Application by North Somerset Council for an Order granting Development Consent for the Portishead Branch Line – MetroWest Phase 1

Hearing Action Points arising from the Issue Specific Hearing 2 dealing with Environmental Matters (day 1 of 2) held virtually on Monday 11 January 2021

Drawing
PORTISHEAD STATION CAR PARK
LAYOUT, LANDSCAPING AND NEW
BOULEVARD AND ACCESS PLAN
SHEET 2 OF 3

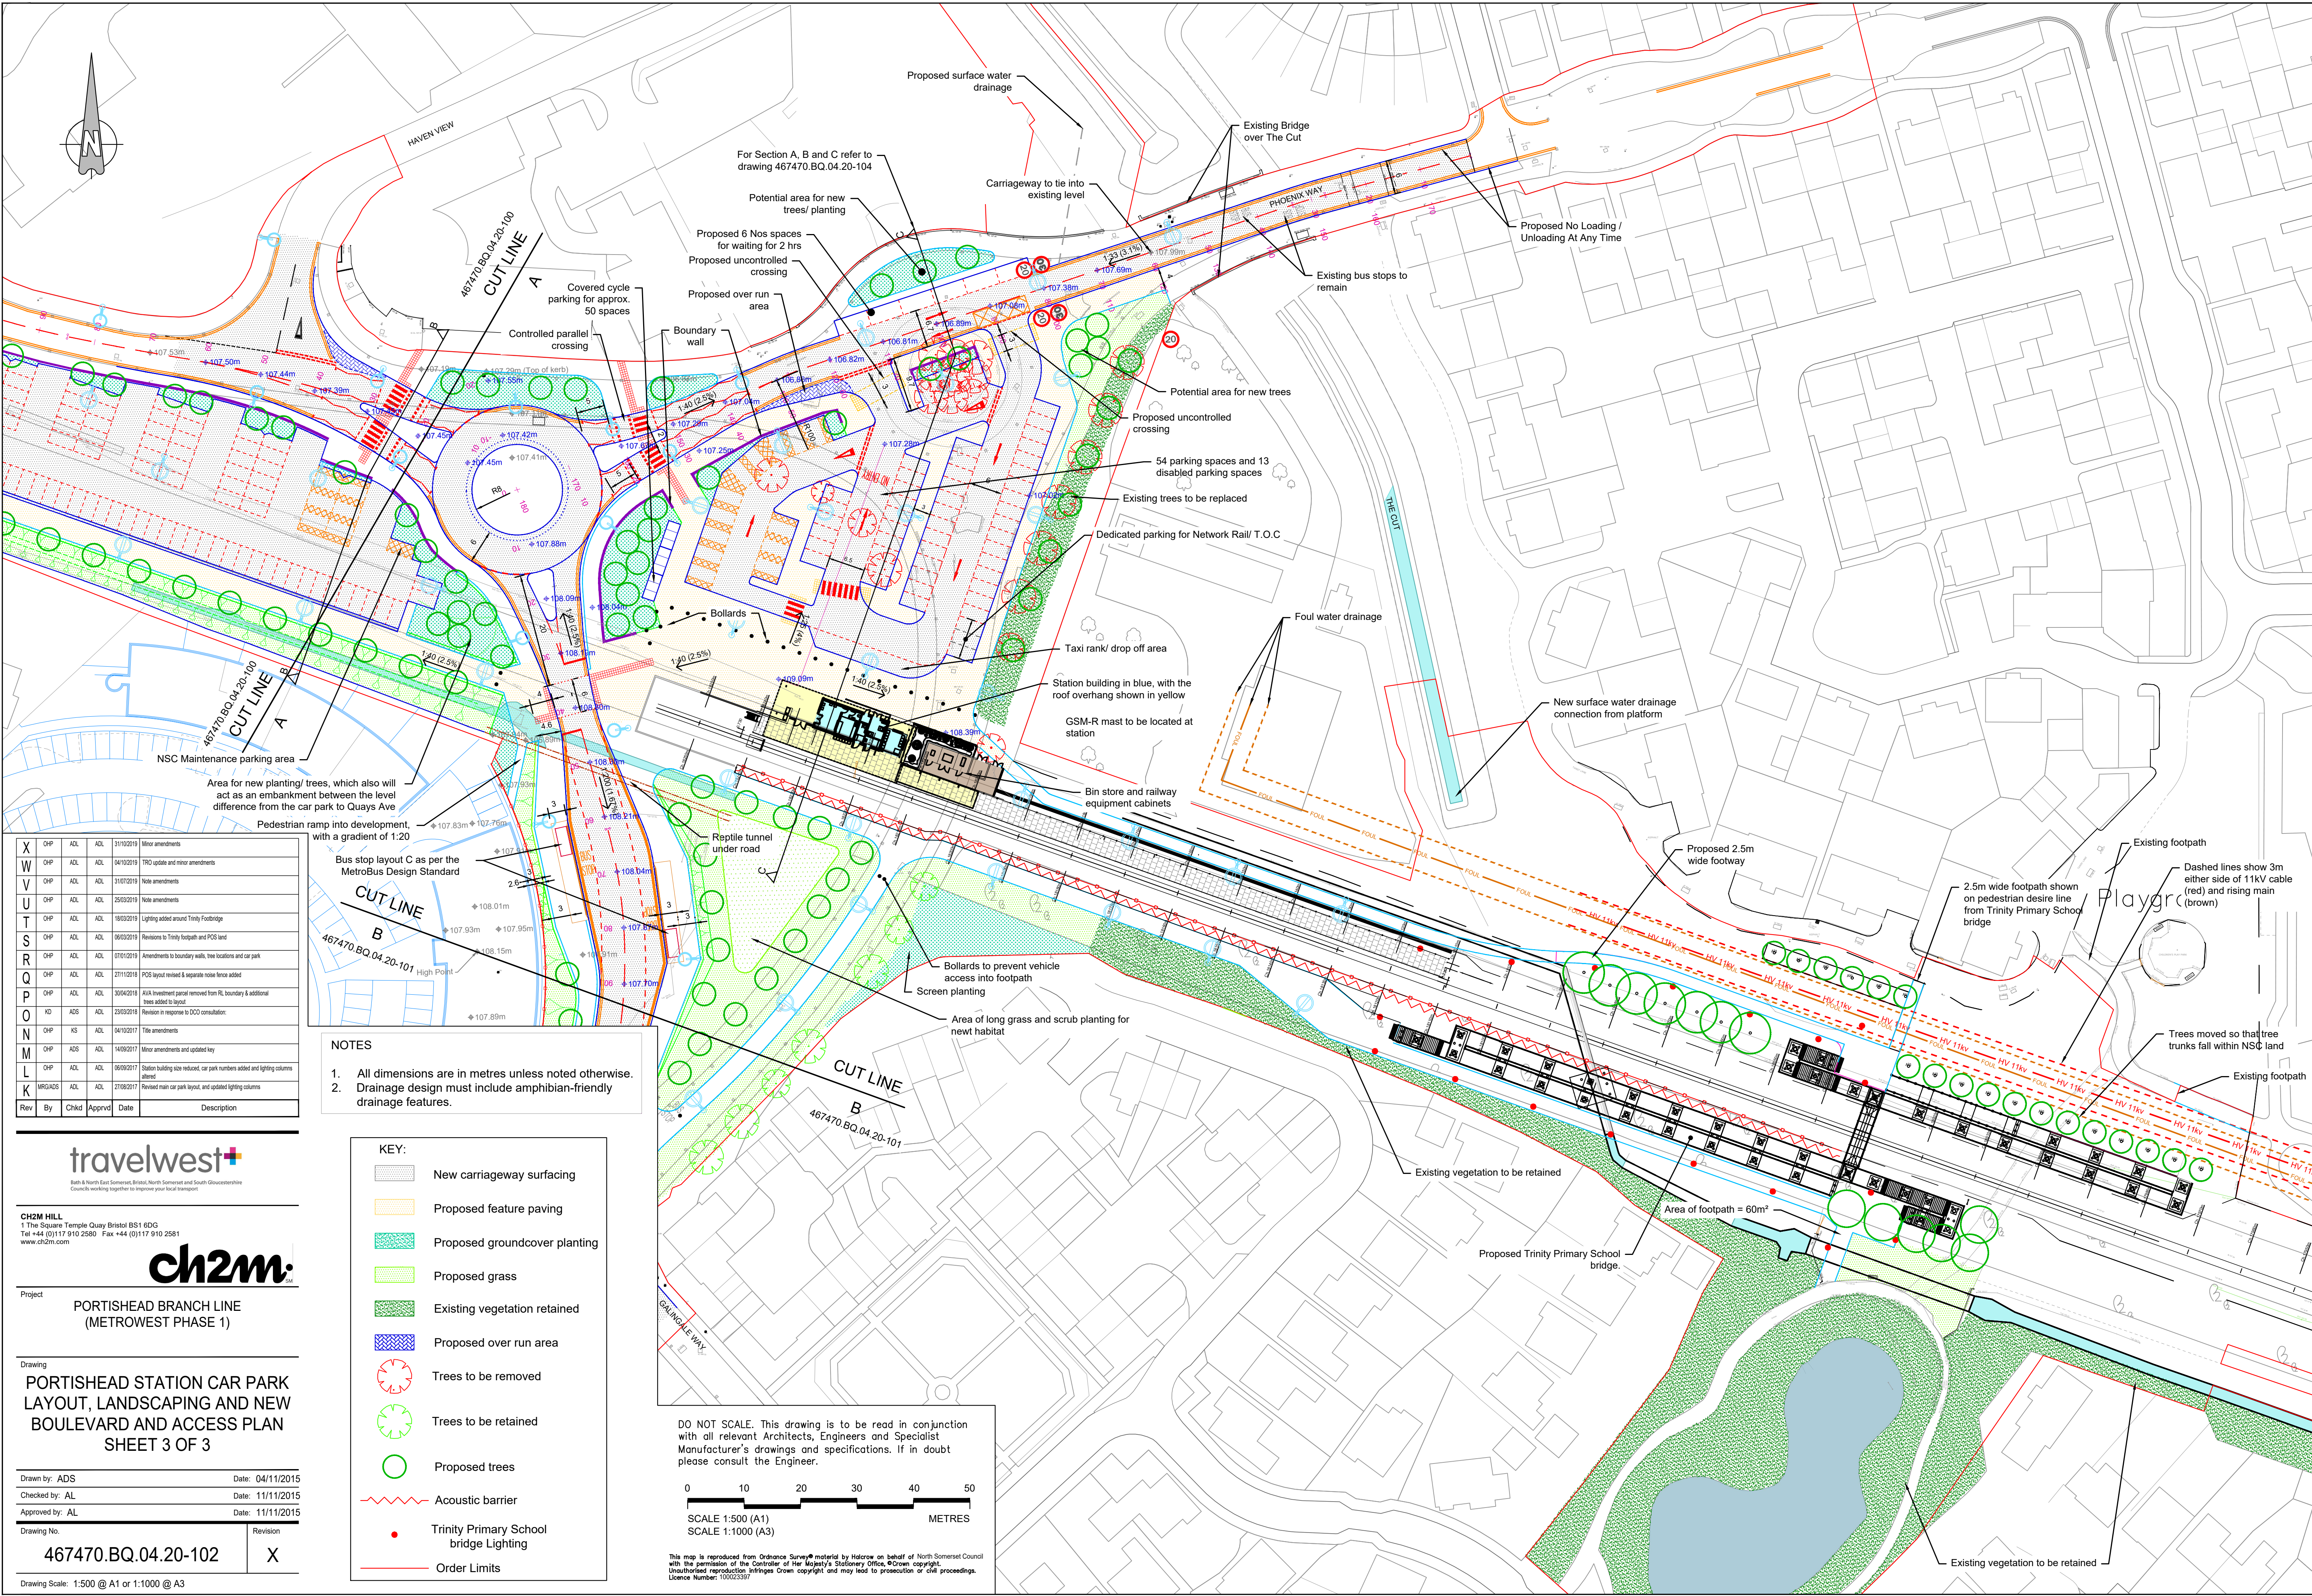
Action	Description	Action by	When
1	Consider what energy-efficiency/ micro-generation measures that could be incorporated into the design of Portishead Station and explain how these would be secured	Applicant	Deadline 4
2	Review the visual impact assessment to see whether the effect of Portishead Station and forecourt on the care home has been assessed in terms of setting of and outlook from the care home and signpost where in the application documentation this assessment is. If it has not been assessed either provide an assessment or an explanation as to why such an assessment would not be necessary. Confirm the correct name of care home	Applicant	Deadline 4
3	Invite the Town Council as they were not in attendance at the hearing the opportunity to provide any further comments on the design of Portishead Station and footbridge following the comments made at the hearing	Portishead Town Council	Deadline 4

PILL STATION CAR PARK
AND PSP LAYOUT, LANDSCAPING
LIGHTING AND ACCESS PLAN
SHEET 2 OF 3

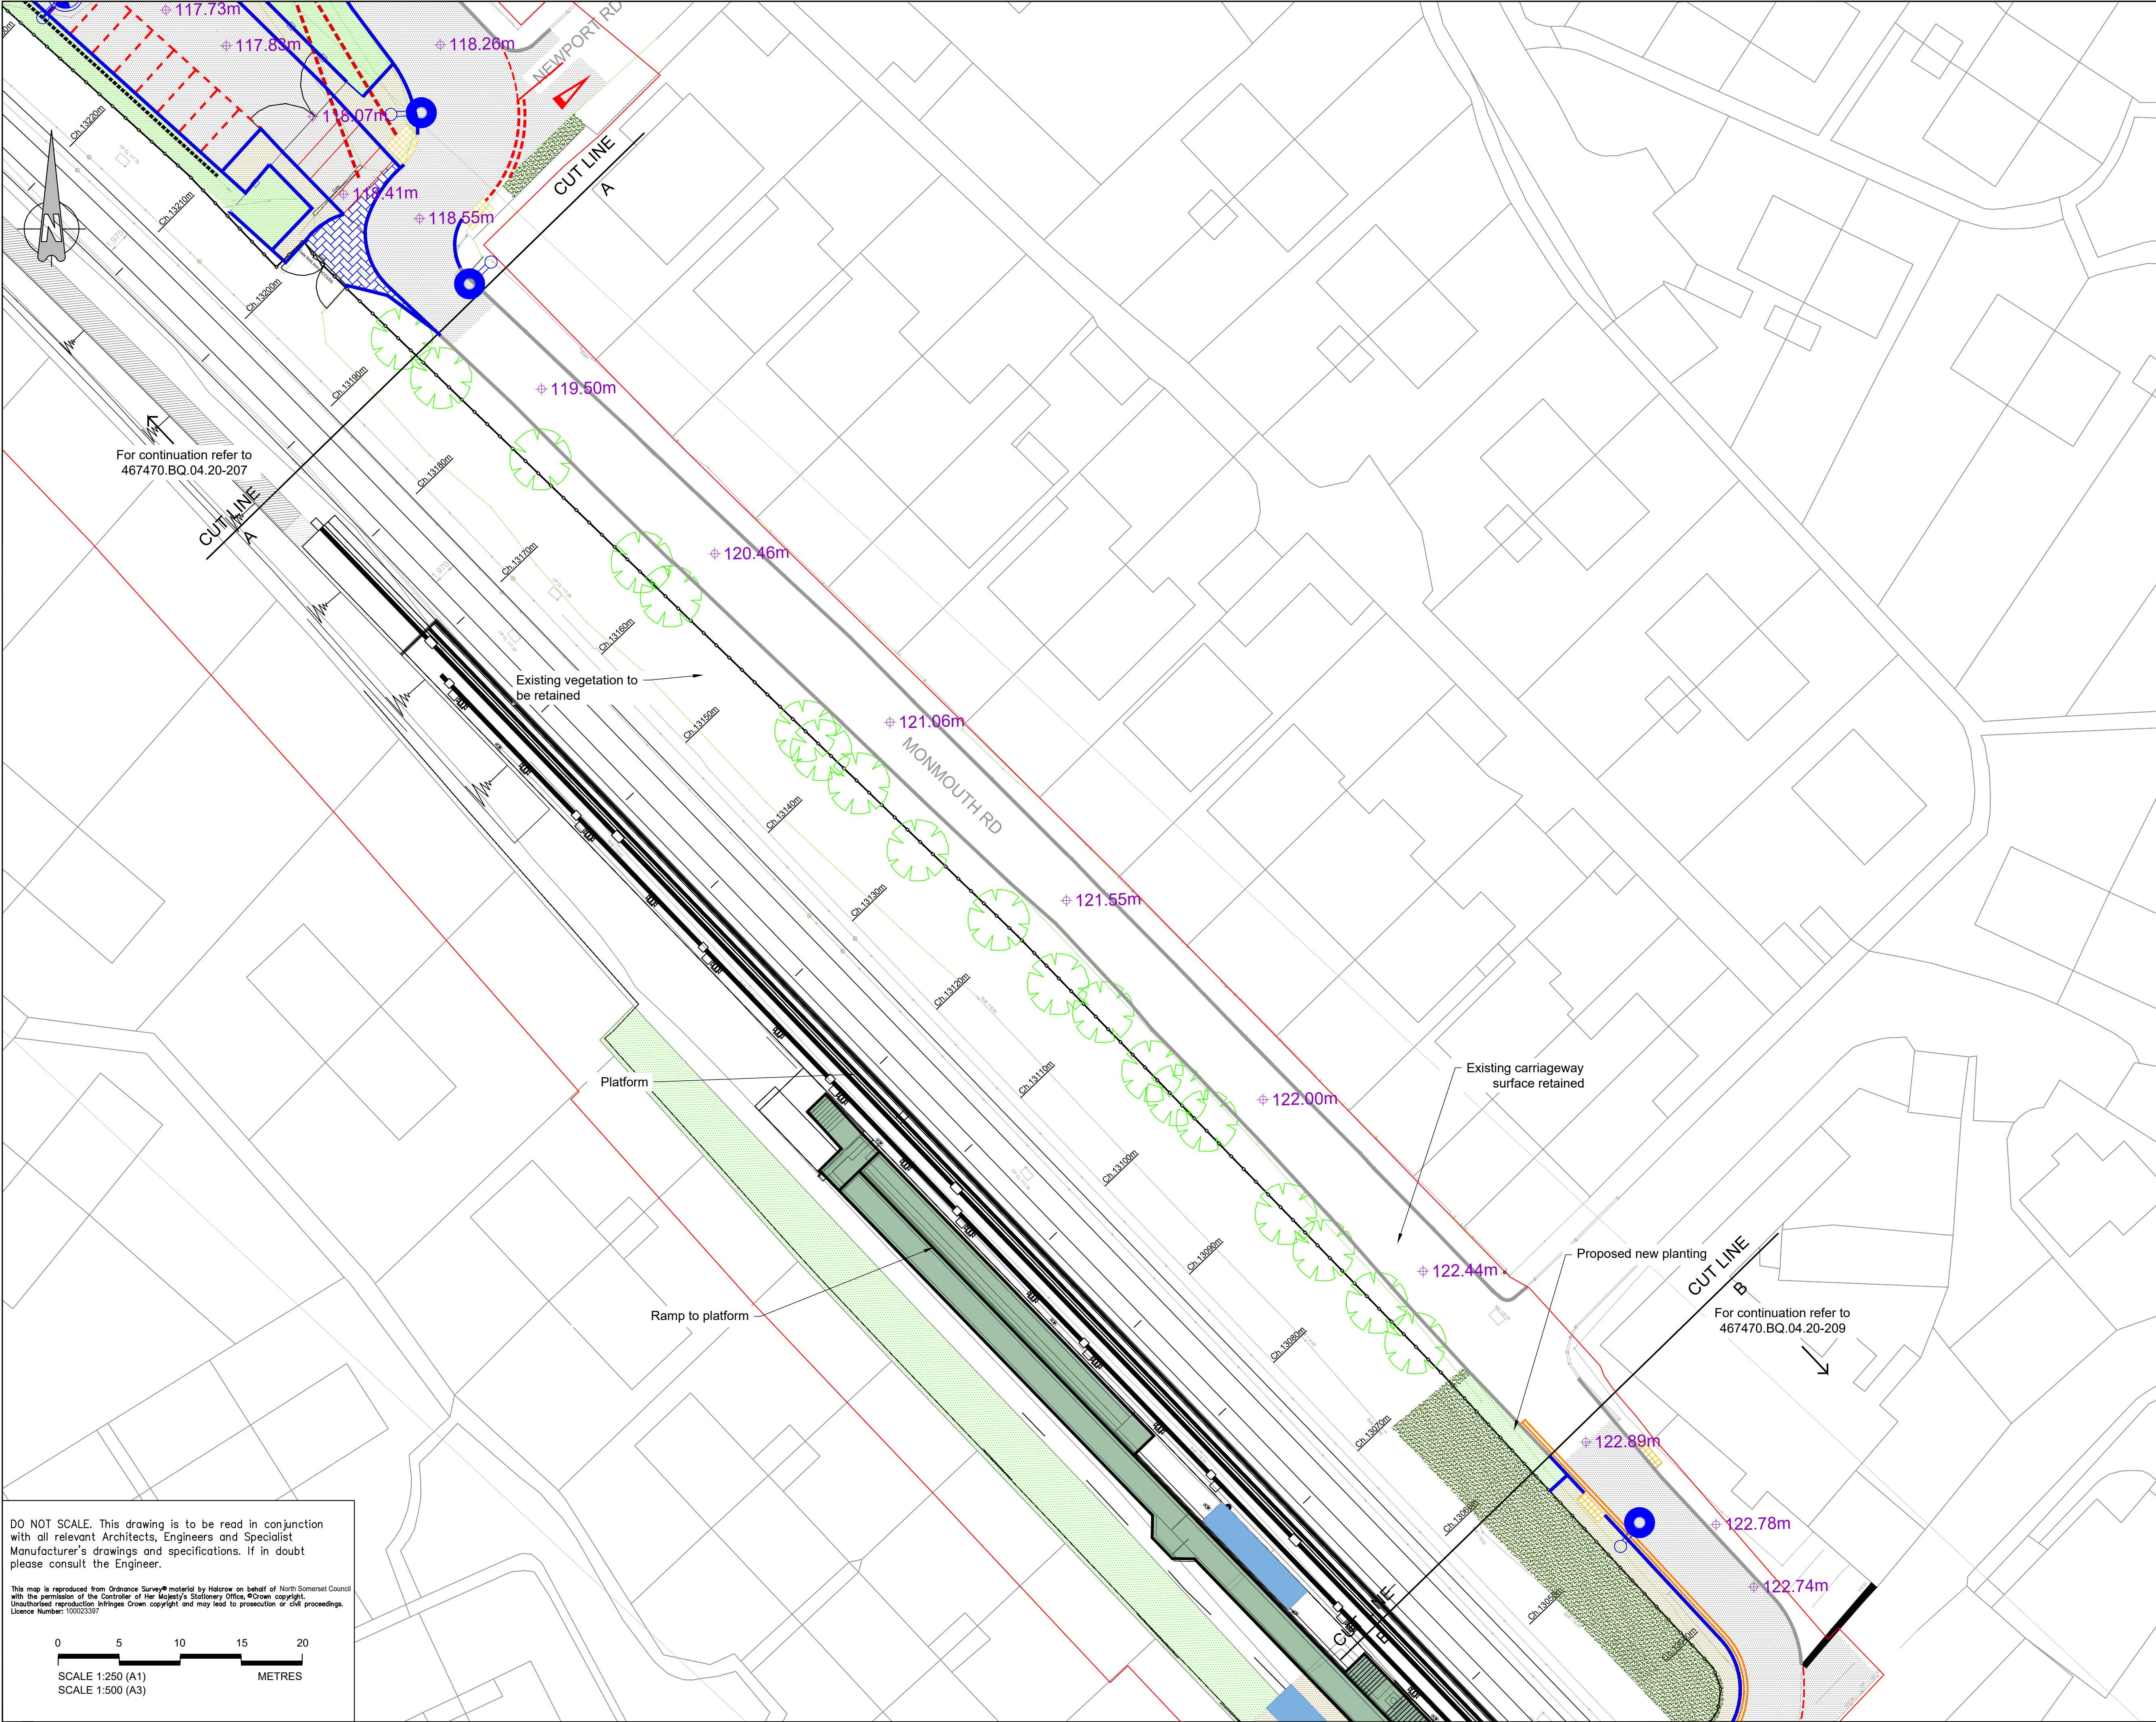
10	Advise whether the fencing around the car park at Pill would be coloured. If it is what colour would it be and how would this be secured? If it is not to be coloured, why not?	Applicant	Deadline 4
11	Provide detail of how the size of the proposed shelter at Pill Station was decided, including details of how many people it would be able to accommodate and whether it would be sufficient to meet the needs of users of the station	Applicant	Deadline 4
12	Provide further detail of the design of the proposed fencing in the Avon Gorge and whether it would replace the existing post and wire fencing that currently runs through the Avon Gorge.	Applicant	Deadline 4
